**REQUEST**

Current Zoning: NC (neighborhood center)  
Proposed Zoning: CG(CD) (general commercial, conditional)

Approximately 0.434 acres located along the east side of Beatties Ford Road, south of Holly Street, and north of Dr Webber Avenue.

Fifth Third Bank

**FIFTH THIRD BANK  
REZONING PETITION NO. 2023-XXX  
10/19/2023**

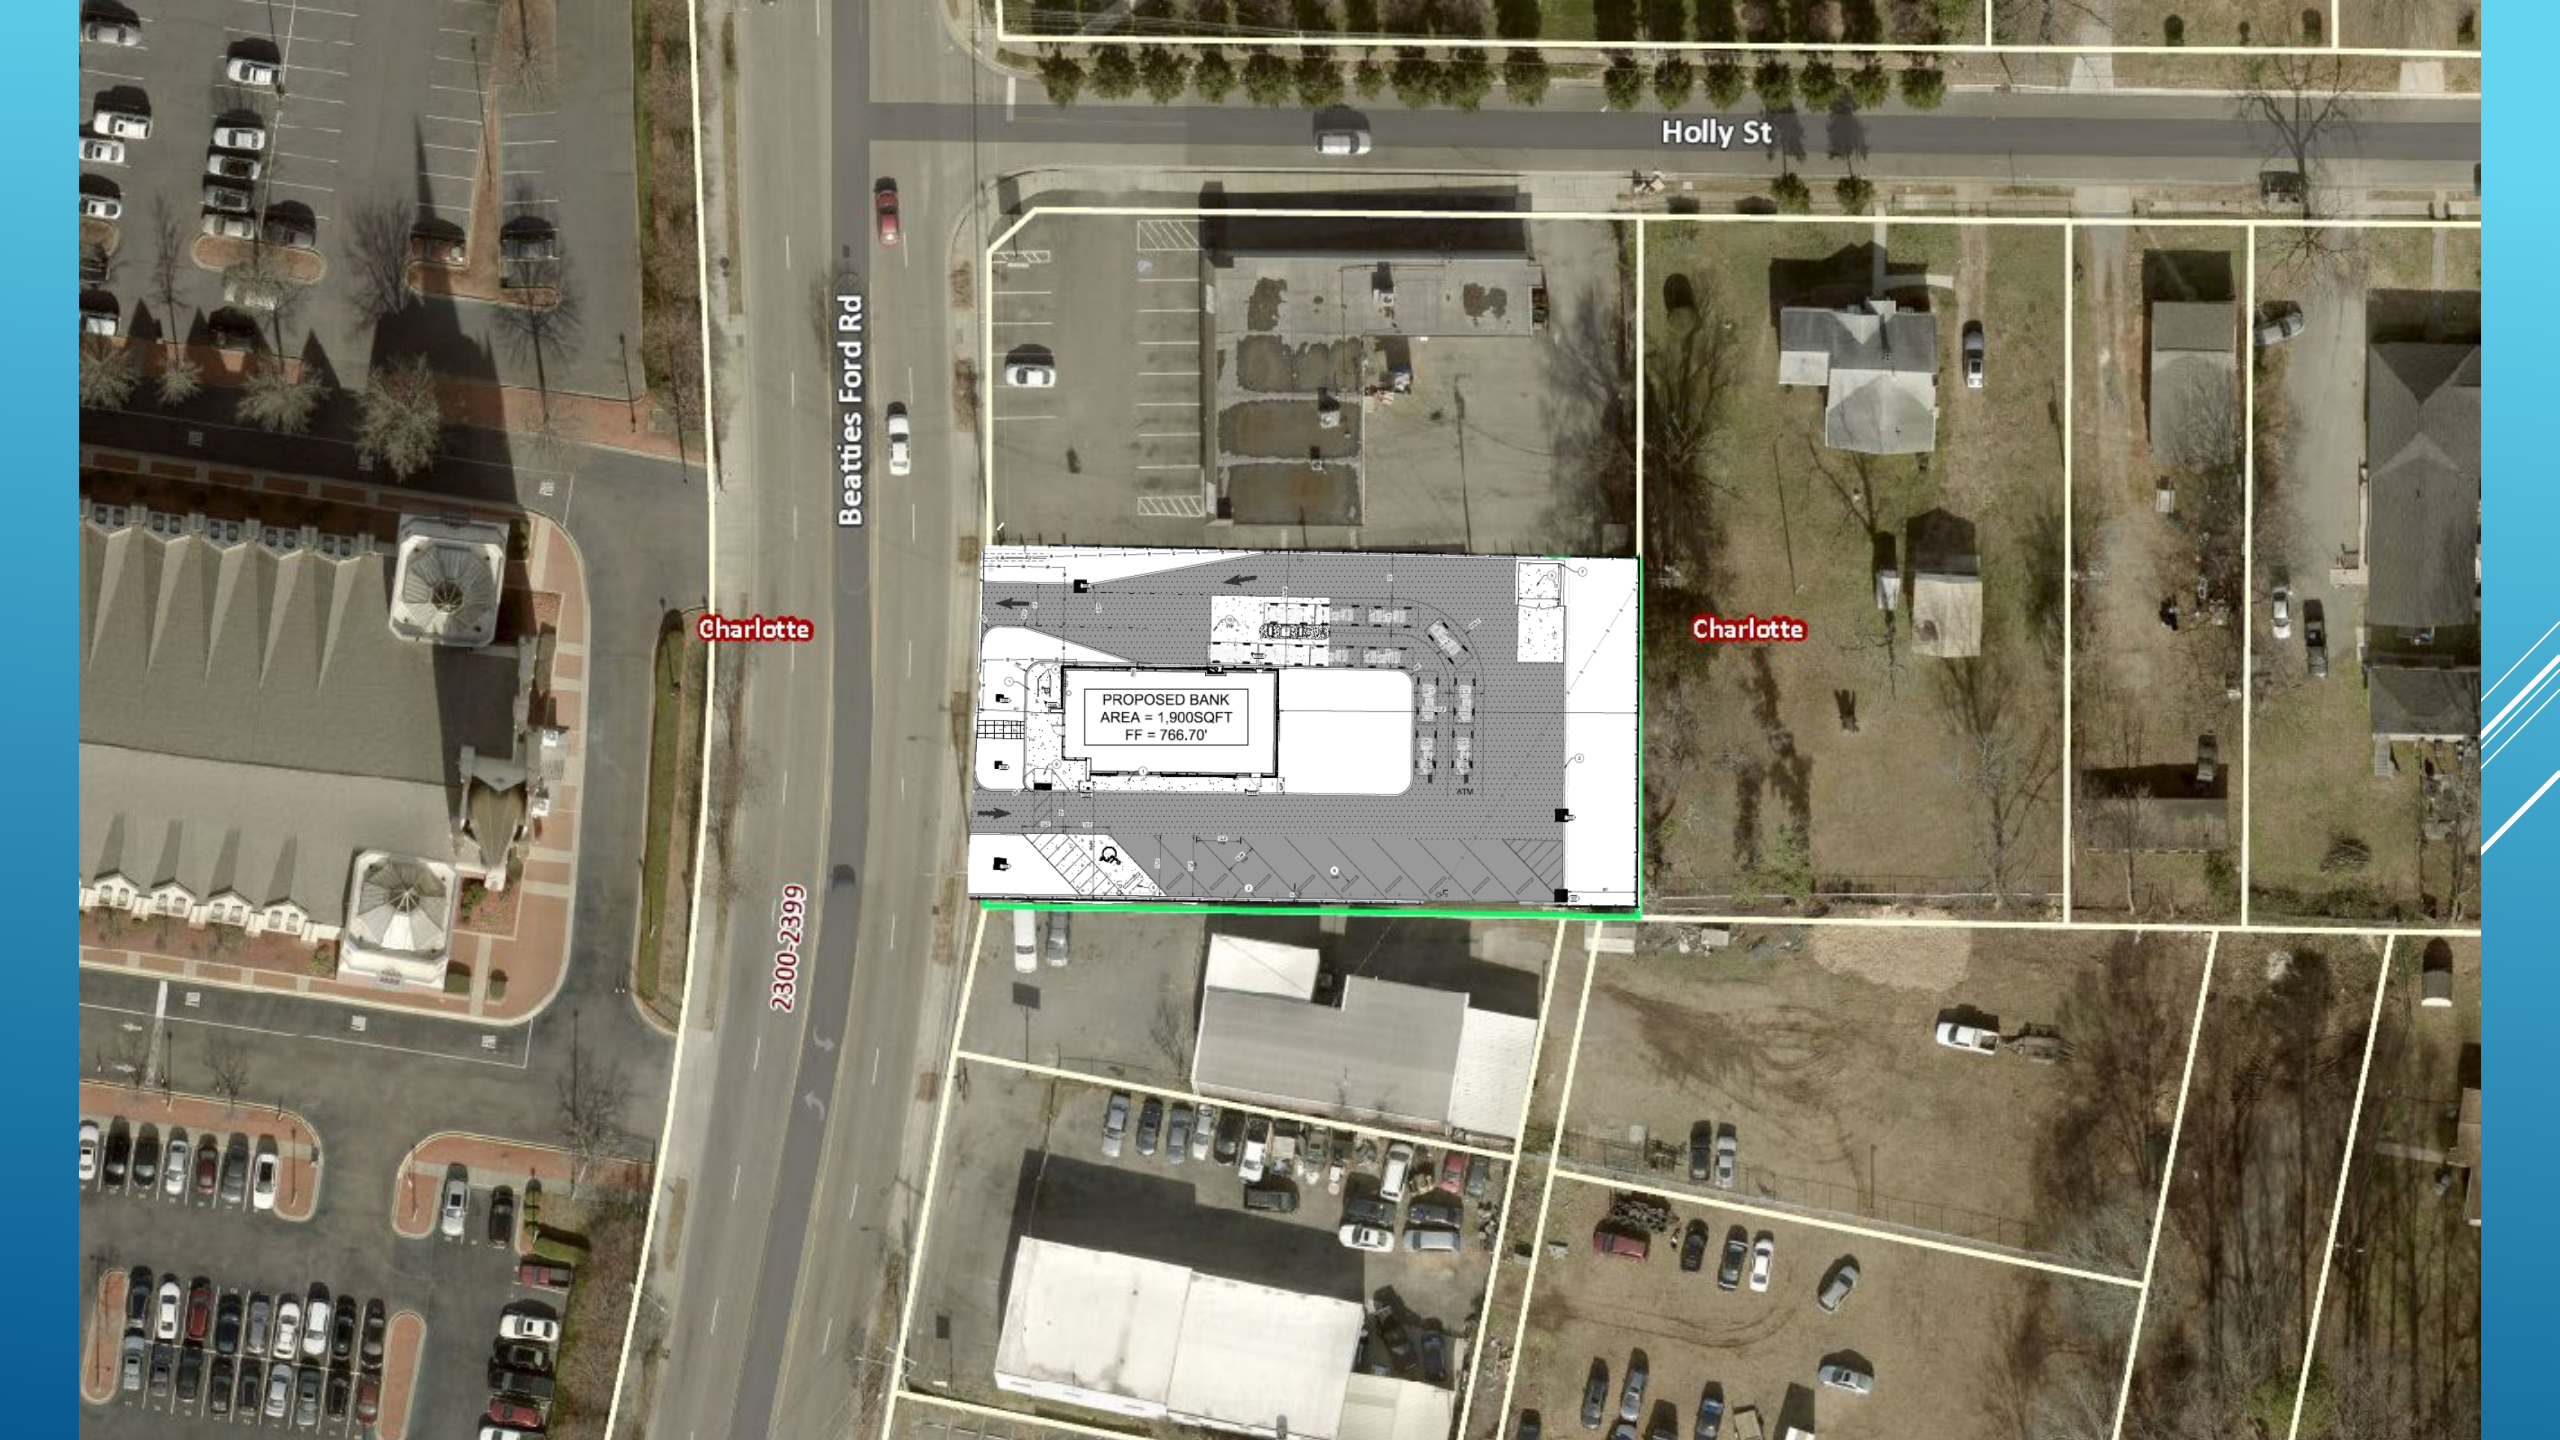
- ~~1. Specify where the drive through windows would be placed.~~ **Addressed**
  - ~~2. Specify if the elimination of a travel lane in the front of the building could allow for the development of a plaza space or green area.~~ **Addressed**
-

- Allow all uses permitted by-right and under prescribed conditions together with accessory uses as allowed in the general commercial district.
- Drive-through lanes and circulation shall not be placed between Beatties Ford Road and the front façade of the building.
- Accessory drive-through service uses shall be located along the northern façade of the building and service lane.
- A plaza or green space area shall be located between the building and Beatties Ford Road.
